Address: 53, Orchard Street, Dewsbury, WF12 9LH

Application number: 2026/91233	
What is the application for?:	Erection of detached dwelling
Address of the site or building:	50, Orchard Street, Savile Town, Dewsbury, WF12 9LH
Postcode:	WF12 9LH

Type of comment: An objection	
Do you wish your comments to be published on the website anonymously?	No

Site/ Roof Plan As Proposed
Scale 1:100

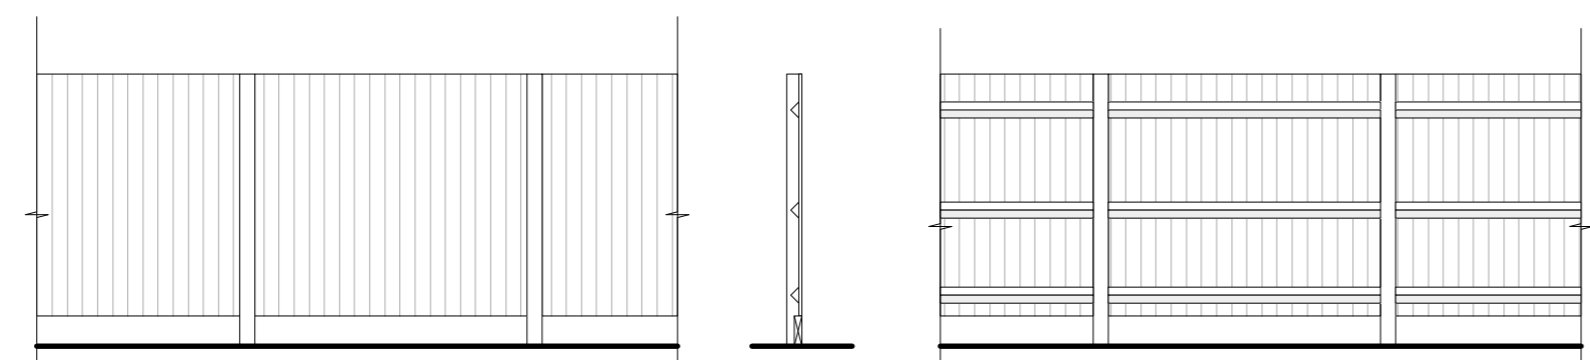
The garages are already located in a tight residential setting, where space for vehicles to enter, leave, turn and manoeuvre is limited. The proposed detached dwelling would introduce a large new building, additional vehicles, parking demand, bin storage, deliveries and general domestic use into an area that is already constrained. In my view, the application does not properly explain how the existing garage access will be protected or how vehicles will continue to manoeuvre safely without obstruction.

I am particularly concerned that the development could make it more difficult to access my garage, especially during busy periods, when vehicles are parked nearby, or during construction works. Even small changes to parking or vehicle movements in this location could have a noticeable impact because of the limited space available. The Council should not approve the application unless it is fully satisfied that access to the existing garages will remain safe, practical and unobstructed.

The corner location of the site also raises highway safety concerns. Any new dwelling here would create additional vehicle movements close to Orchard Street and Cross Street. This could increase parking pressure and make visibility, turning and access more difficult. The application should clearly show how vehicles connected with the new dwelling would park and manoeuvre without causing obstruction to the garages, nearby properties, pedestrians or other road users.
